**Colorado Springs Airport Advisory Commission Meeting  
To Be Heard October 28, 2020  
Land Use Review Item #10**

<b>EL PASO COUNTY BUCKSLIP NUMBER(S)/FILE NUMBER(S):</b> ADR2012 <i><b>RESIDENTIAL ADMINISTRATIVE RELIEF</b></i>	<b>PARCEL #(S):</b> 5507206060
<b>DESCRIPTION:</b> <p>Request by B&amp;J surveying, Inc., on behalf of Richmond American Homes for a dimensional variance to allow a reduced setback of 22' where 25' is required. Reducing the Rear Lot setback from 25' to 22' (20%), allows Richmond to utilize one of their existing floor plans where a plan would not fit into the lot without the Administrative Relief. The setback is for Lot 23 of Springs at Waterview Filing No. 1 (4878 Wolf Moon Drive). The property is zoned RS-5000 (Residential Suburban) and consists of 0.12 acres. The property is located northeast of Grinnell Street and Bradley Road.</p>	
<b>CONSTRUCTION/ALTERATION OF MORE THAN 1 200 FEET ABOVE GROUND LEVEL?</b> No	<b>DISTANCE/DIRECTION FROM COS:</b> 2.2 miles south of Rwy 35L
<b>TOTAL STRUCTURE HEIGHT AT THE ESTIMATED HIGHEST POINT:</b> 30 feet above ground level; 5,910 feet above mean sea level	<b>COMMERCIAL AIRPORT OVERLAY SUBZONES PENETRATED:</b> Accident

PLOT PLAN LOT 23

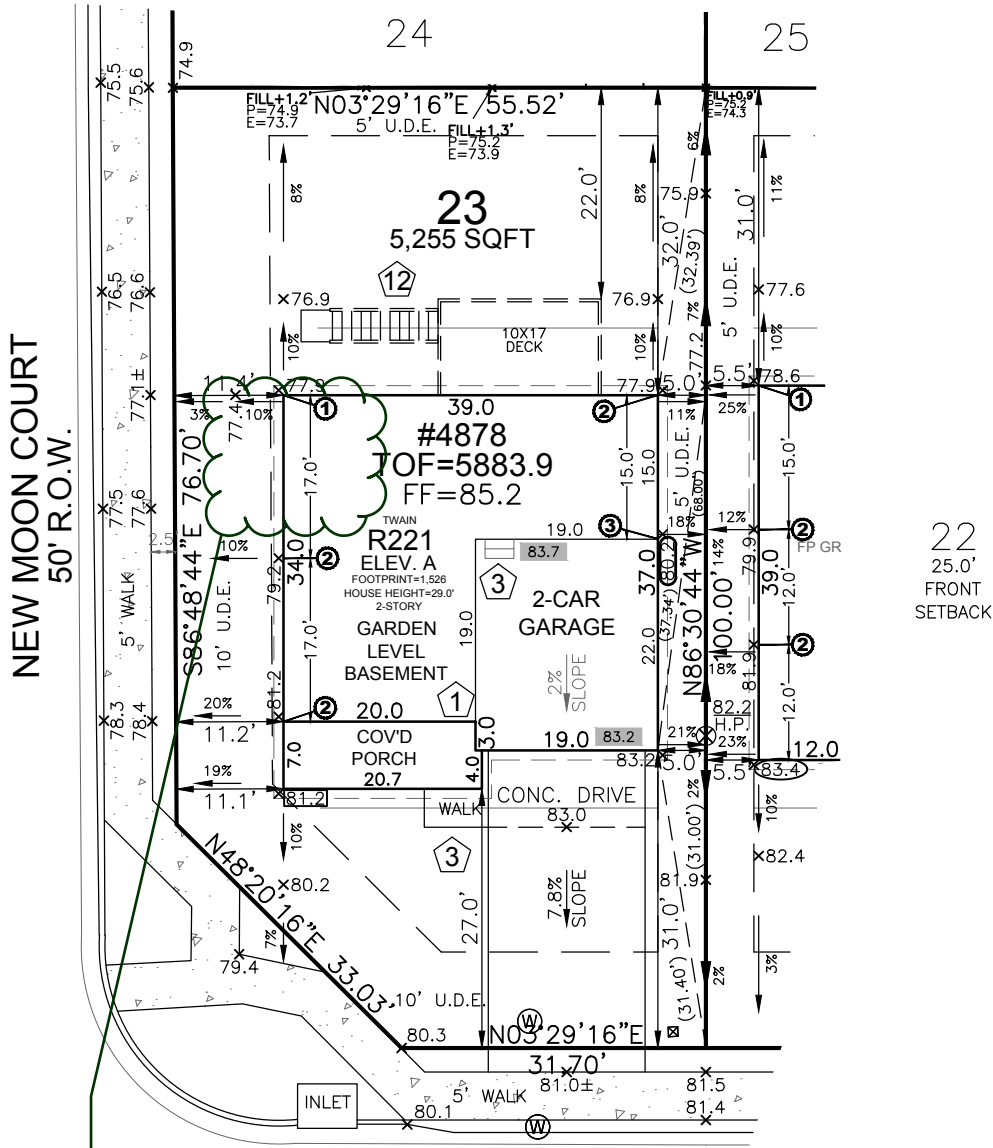
- **Avigation Easement:** Proof of previous Avigation Easement filing was provided in the plat submittal documentation (Reception #213006737); no further action is required.
- **APZ-2:** The property is within the Accident Potential Zone 2 (APZ-2) subzone of the Commercial Airport Overlay District, as adopted by El Paso County and is permissible in the APZ-2 subzone.
- **FAA Form 7460-1:** Based on elevation data and distance to runway, the applicant will need to file Federal Aviation Administration (FAA) Form 7460-1 "Notice of Proposed Construction or Alteration" for any new vertical development at this site, including temporary construction equipment, and provide FAA documentation to the Airport before the commencement of construction activities; FAA's website (<https://oeaaa.faa.gov/oeaaa/external/portal.jsp>).
